Application number: 2020/90761	
What is the application for?:	Demolition of existing workshop and erection of dwelling with garage/workshop at
Address of the site or building:	land between, 12 & 14, Knowl Road, Mirfield, WF14 8DQ
Postcode:	WF14 8DQ

Type of comment: An objection

Revisions

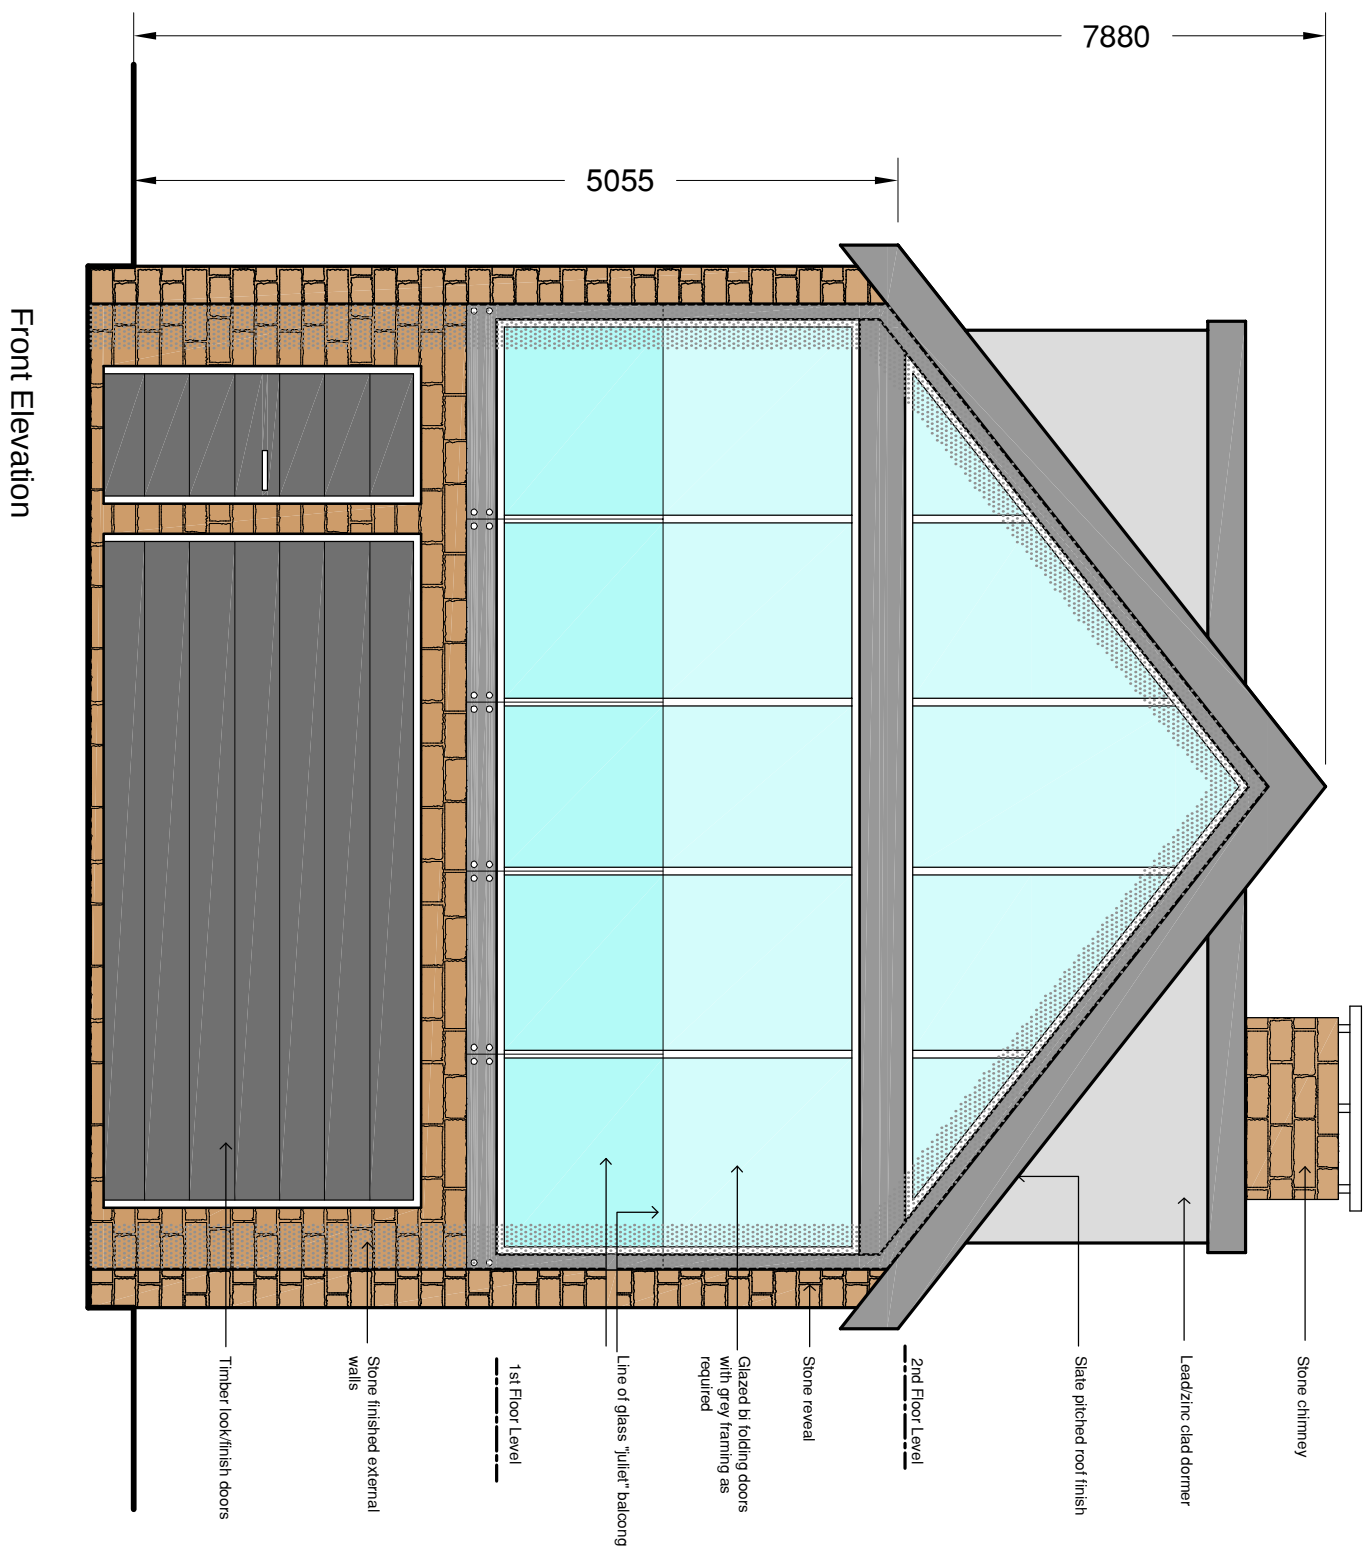
1) The previous application was declined due to the development would result in a large three storey building located in very close proximity to the Public Right of Way to the south of the site which would result in an overbearing impact on the users of this footpath. This second application shows a building of a very similar height, the main difference the third floor being a Dormer style rather than simply a pitched roof - this objection therefore still stands.

2) The previous application was declined due to the development would not promote good design, failing to respect the local character of the area and context in which it would be located. The dwelling would detract from the areas as a result of the mixed palette of materials, none of which are evident in surrounding dwellings which are of traditional appearance. The second application shows a building which has a fully glazed first and second floor fronts to the building, along with render with a Juliet balcony. As a result of poor siting of the dwelling in a cramped site, the proposed development represents poor design and overdevelopment of the application site - this objection therefore still stands.

4) The previous application was declined as by virtue of the proximity of the proposed dwelling to the existing dwellings surrounding the site and the positioning of openings and windows to the front of the proposed dwelling, it would result in a detrimental overbearing and overlooking impact on nos. 10, 14 and 16 Knowl Road, failing to ensure that the existing occupiers of surrounding development would have a high standard of amenity which is required- this objection still stands.
